Please ask for: Ms Iqraa Malik
Email: iqraa.malik@terraquest.co.uk
Telephone: 0121 234 1390
Our Ref: FG/178/21/HH
Your Ref:
Date: 21st October 2021

Application for Planning Permission for Works or Extension to a Dwelling

Development: Single storey front extension, two storey side extension and section of rear dormer
Location: 12 Colindale Road North Ferring BN12 5LB

BLOCK PLAN 1:500

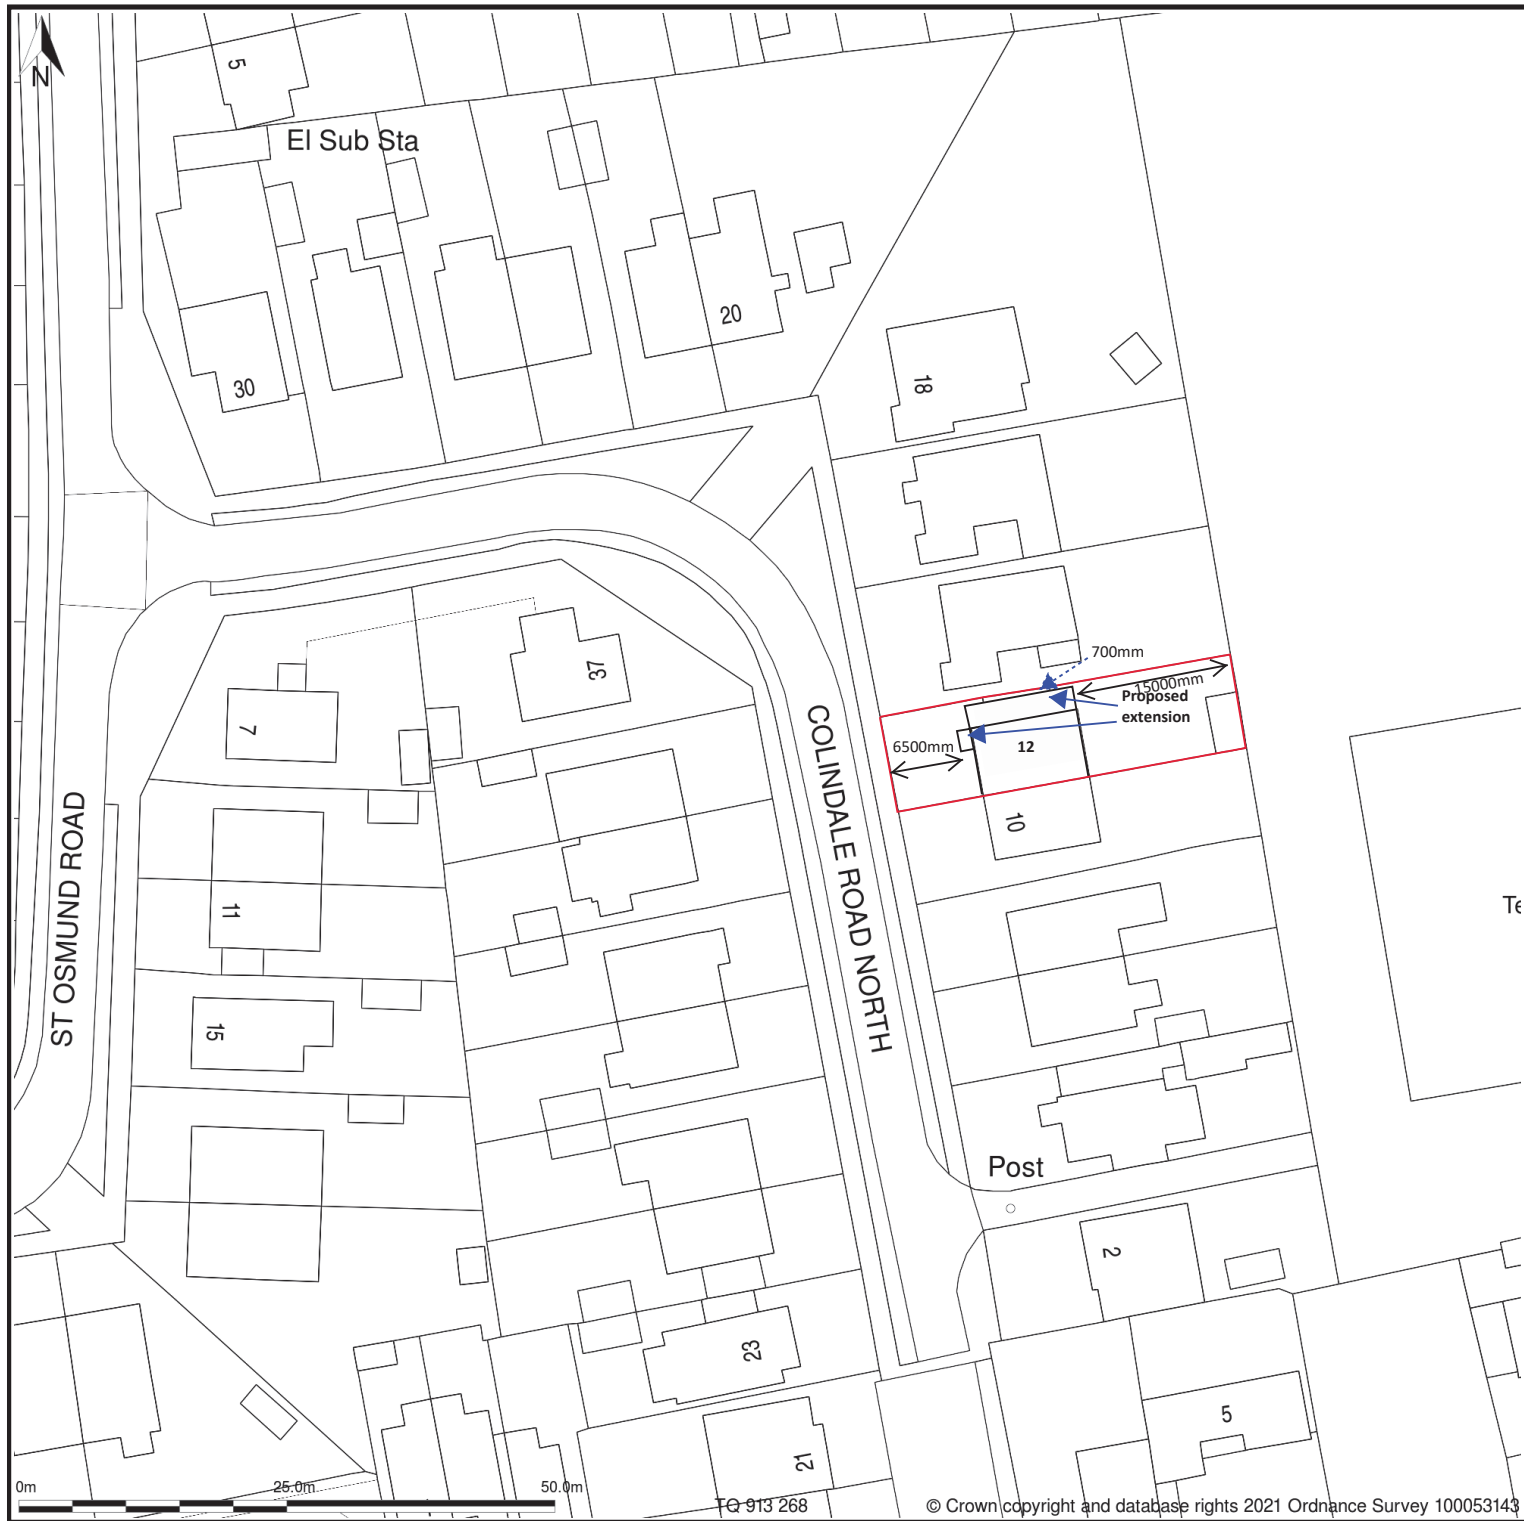
Block Plan

You are required to have dimensions from the proposed extension(s) to all site boundaries. Please amend.

EXISTING FRONT ELEVATION 1:100

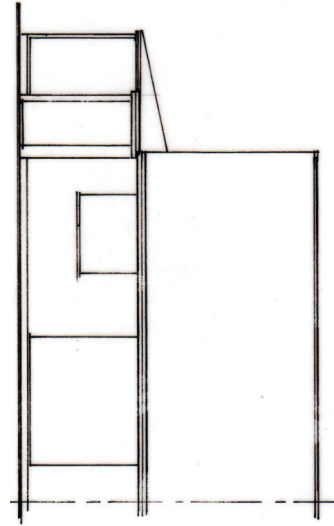
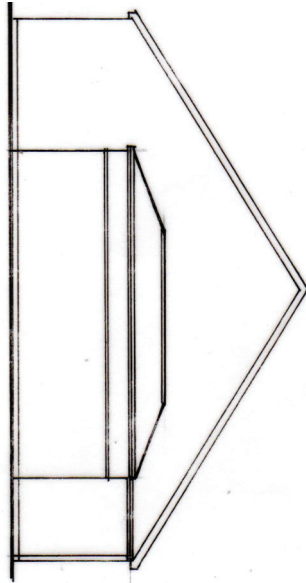
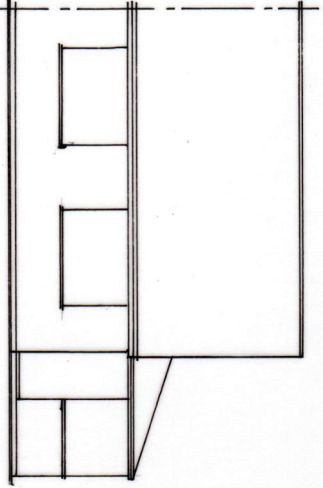
Elevations

Please submit existing elevations at a scale of 1:50 or 1:100. Further details can be found in the Validation Requirements List.
